WEST SUSSEX COUNTY COUNCIL CONSULTATION

TO:	Arun District Council - FAO: HARRY CHALK
FROM:	WSCC – Highways Authority
DATE:	10 October 2025
LOCATION:	Land at London Road and Land West of and adjoining Anne Howard Gardens Arundel
SUBJECT:	AB/122/25/OUT Outline application with all matters reserved except access for the erection of up to 6 No dwellings with associated access, parking and landscaping. This application affects the setting of listed buildings, affects the character and appearance of the Arundel Conservation Area and is a Departure from the Development Plan.
DATE OF SITE VISIT:	10 October 2025
RECOMMENDATION:	More Information

West Sussex County Council, in its capacity as Local Highway Authority (LHA), have been consulted on proposals for 6 x dwellings and associated works on land west of Anne Howard Gardens. The application is outline with matters of access only sought for approval. The application is supported by a Transport Statement (TS).

Proposed Site Layout & SuDS Drainage Strategy Layout

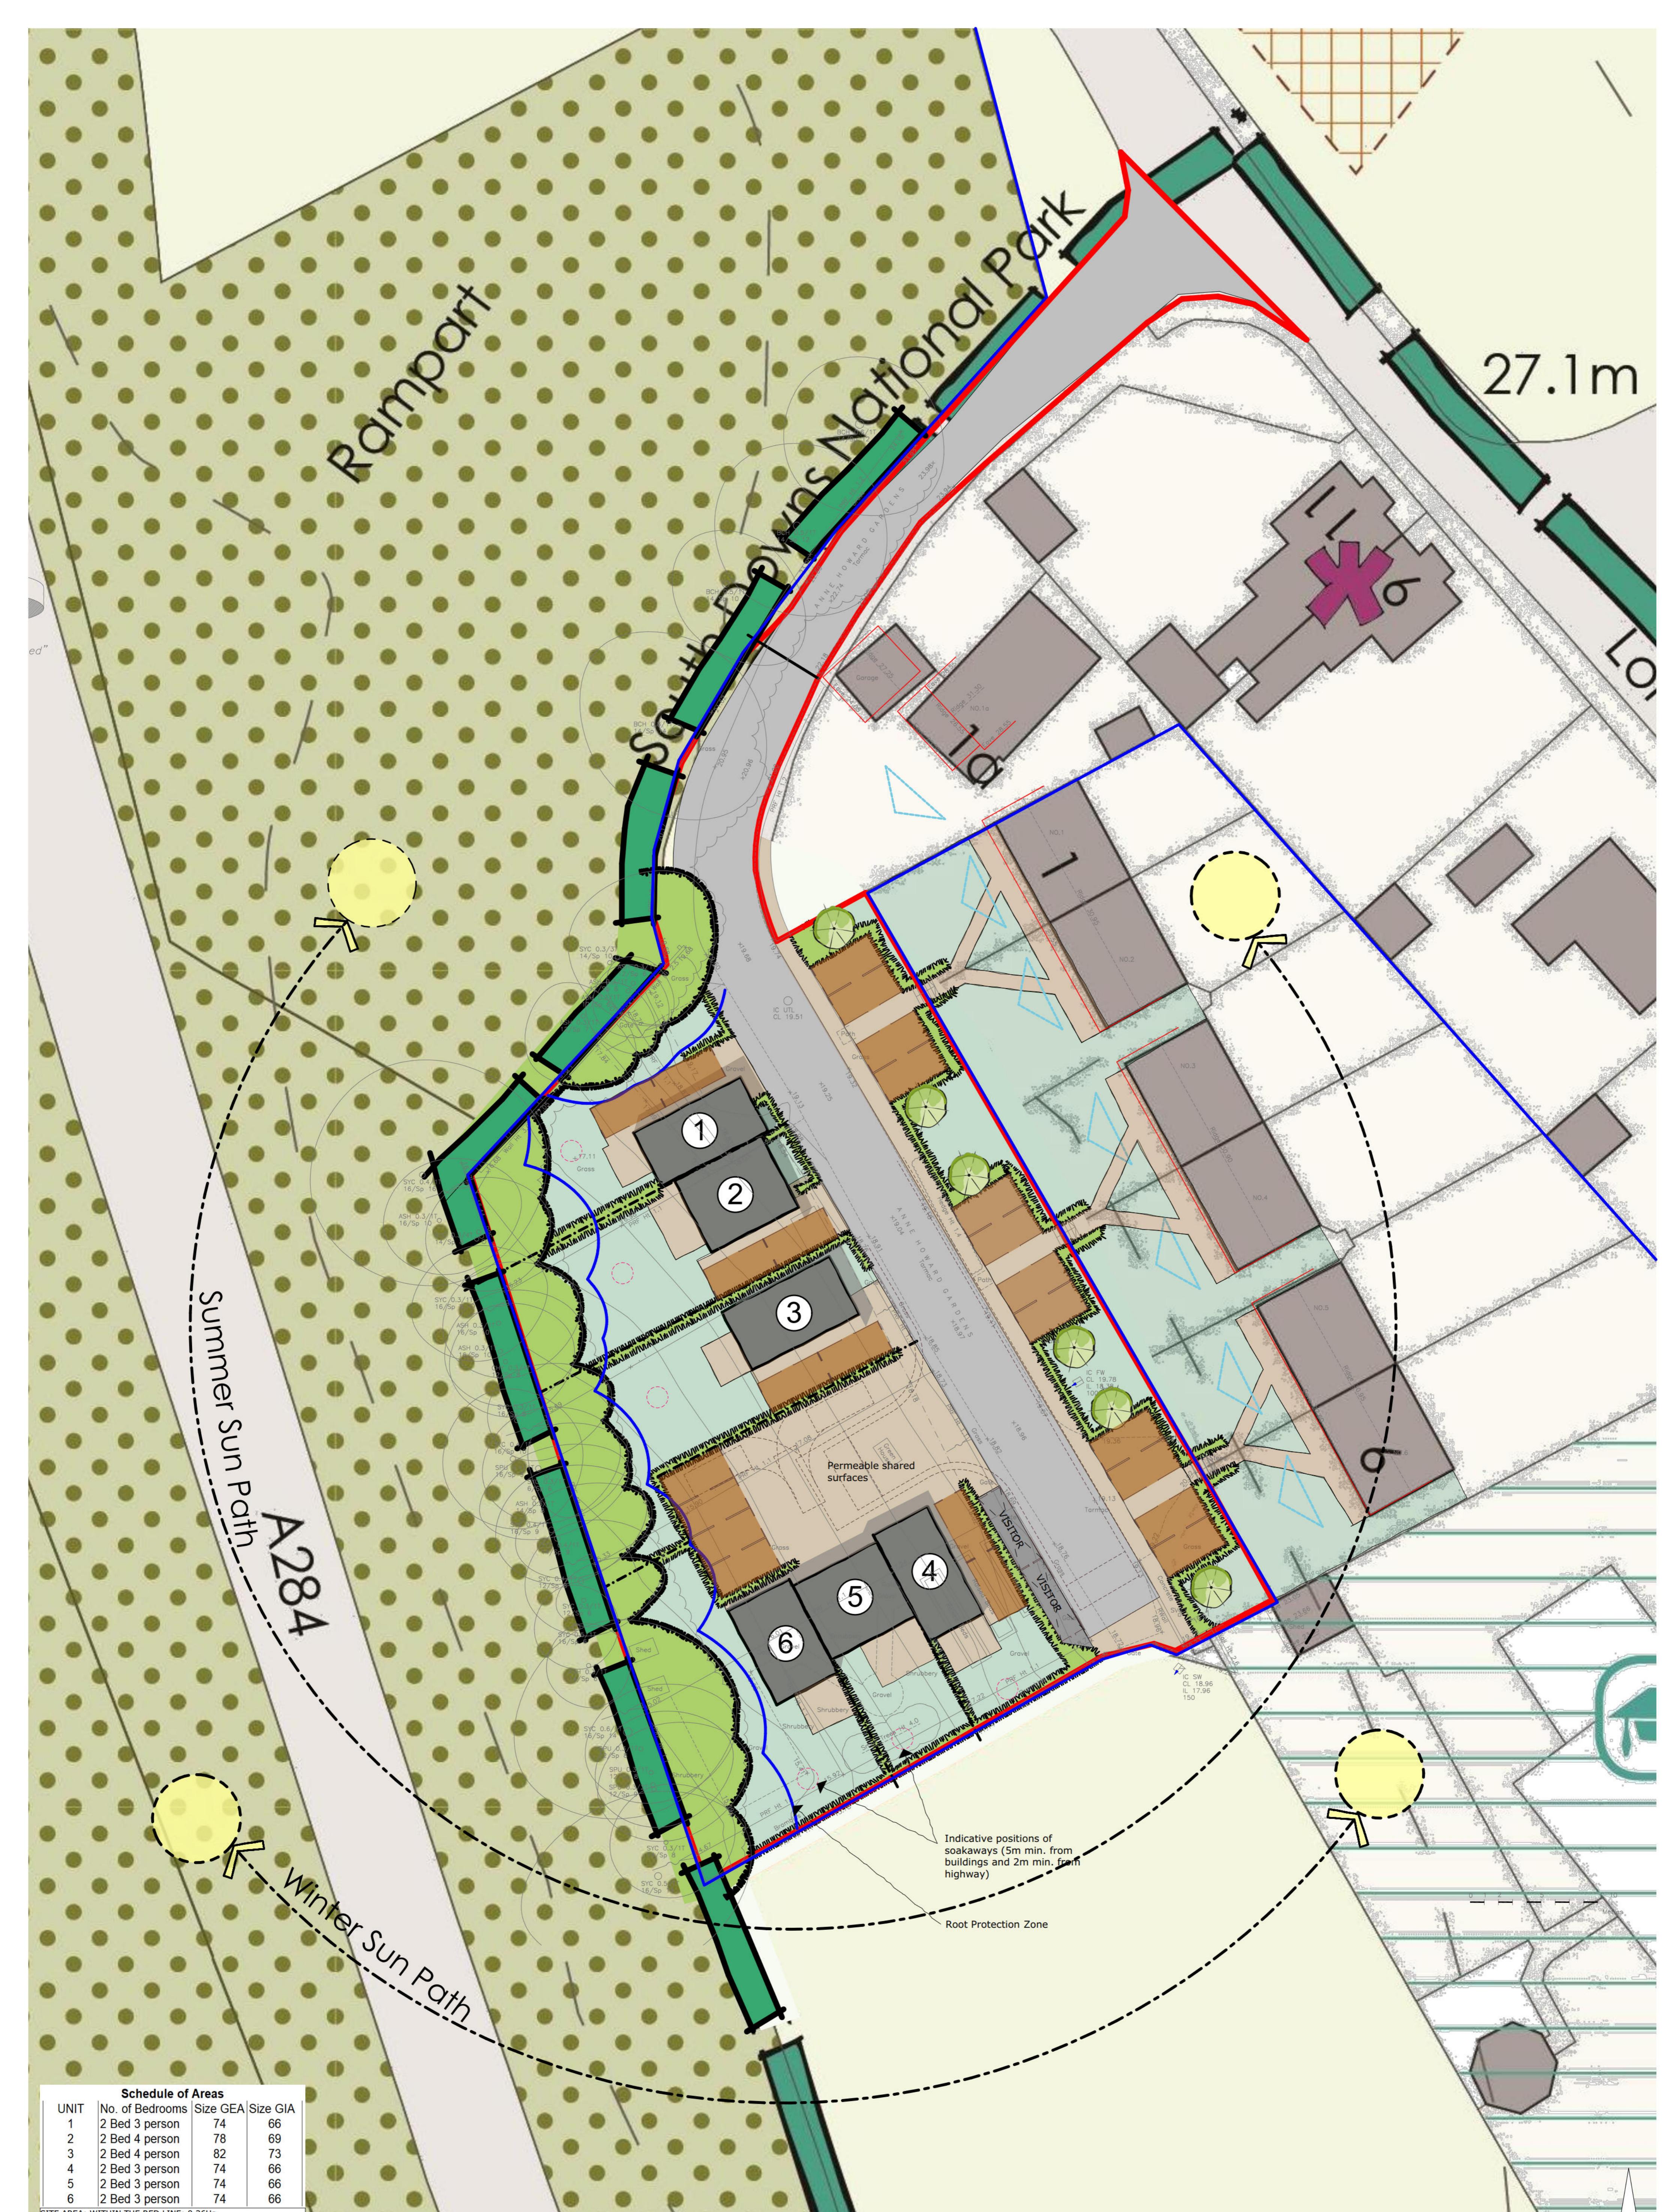
Vehicle and pedestrian access will be from Anne Howard Gardens as existing with the cul-de-sac acting as shared surface which is appropriate for the anticipated vehicle speeds and volumes. A formalised turning head is also proposed to allow refuse, fire and car vehicle turning area demonstrated as achievable via swept path tracking. TS states a preference for the road to become adopted for which a s38 application would be required. Currently the road is privately maintained thus any works within it

would not require licence/technical approval from WSCC. However, the site visit revealed that the existing footway which wraps around southern side of access and is within publicly maintained highway does not include a suitable transition to the shared surface arrangement on Anne Howard Gardens. It was also observed that the carriageway width did not allow for two-way vehicle movement however vehicle speeds and volumes are anticipated to be low. Ideally the applicant should propose a transition from the full height footway/kerb to the carriageway (section which is in public highway and would require minor works licence) and confirm whether the road will be proposed for adoption. These improvements would help provide *safe and suitable access for all* (National Planning Policy Framework).

The dwellings are likely to be 2-bed which under Arun SPD Parking Standards would require 2 spaces per dwelling which is shown (plus 2 x spaces per existing dwelling). 2 x visitor bays are also proposed which meets with requirement for 20% of total number of residential units (6 x existing + 6 x proposed). Cycle parking should be provided in line with Arun SPD –and full details would be expected at reserved matters stage.

Whilst the principle of the application is not anticipated top result in highway safety or capacity concern, the LHA request that the applicant consider providing tactile paving improvements (potentially Mount Pleasant) and confirm with certainty whether Anne Howard Gardens will be proposed for adoption, as well as exploring improvement to the existing full height footway where it transitions to shared surface.
